CWWTPR DCO Examination**Submission by Save Honey Hill Group****SHH 34 Response to the Applicant's Responses to Written Representations AW 8.13 [REP2-038]****22 January 2024**

This is an expanded version of SHH34 submitted on 18 December 2023, with responses from Melissa Murphy KC and Esther Drabkin-Reiter, of counsel. The intention to submit this was noted in SHH-037. It is submitted in clean and track change versions. SHH's response refers to Table 2-11 and quotes the paragraph numbers in the SHH WR as used in REP2-038

**Viewpoint 23: Users of Footpath Milton 162/1 and users of the River Cam looking east**

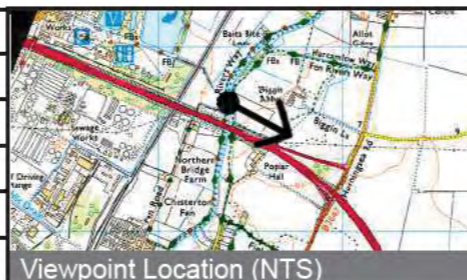
| <p>8.2.8</p> | <p>Viewpoints</p> | <p>SHH notes the Applicant’s guidance about viewing photomontages and trusts that the ExA and other parties will be provided with prints at A1 size to enable this to happen.</p> <p>SHH notes the Applicant’s comments on VP 23. In the case of Footpath 85/6, SHH raises concerns here about the sustainability of the mitigation proposed to cover the roof of the discharge outfall from view. The roof is specified as being at or around ground level. In reality, the dDCO has been amended to allow that structure to deviate to be up to 500mm higher than has been designed and assessed. In the context of the low riverbank, this is a potentially substantial upper deviation. Whether it remains practicable to cover the main structure away from the river bank with soil and grass remains to be demonstrated. This will have an adverse</p> | <p>SHH REP-171</p> <p>AW 5.3.15, (AS-048) AW 5.2.15, (AS-034)</p> |

**Viewpoint 25: Users of shared foot/cycle path along Horningsea Road looking south-east**

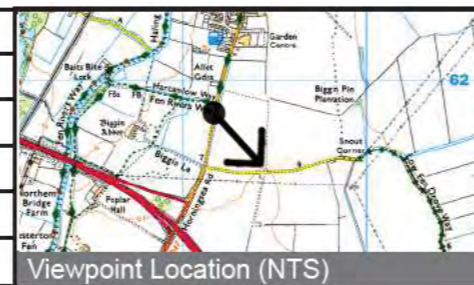
| | | <p>significant impact on visual amenity along this stretch of vegetated river bank, particularly when viewed northwards towards the woodland area and Baist Bite Lock.</p> <p>VP25 SHH maintains the position that this viewpoint should be awarded a high sensitivity rating.</p> <p>VP5 The Applicant in its Response refers to Newmarket Road, however this viewpoint is intended and shown in Fig 15.1 (AS-048) as being on High Ditch Road looking NW towards the PD. The conclusions drawn in SHH 04 (REP-171) relating to VP5, VP7, and VP9 stand.</p> <p>VP 28 SHH notes and accepts the Applicant's comments.</p> | |
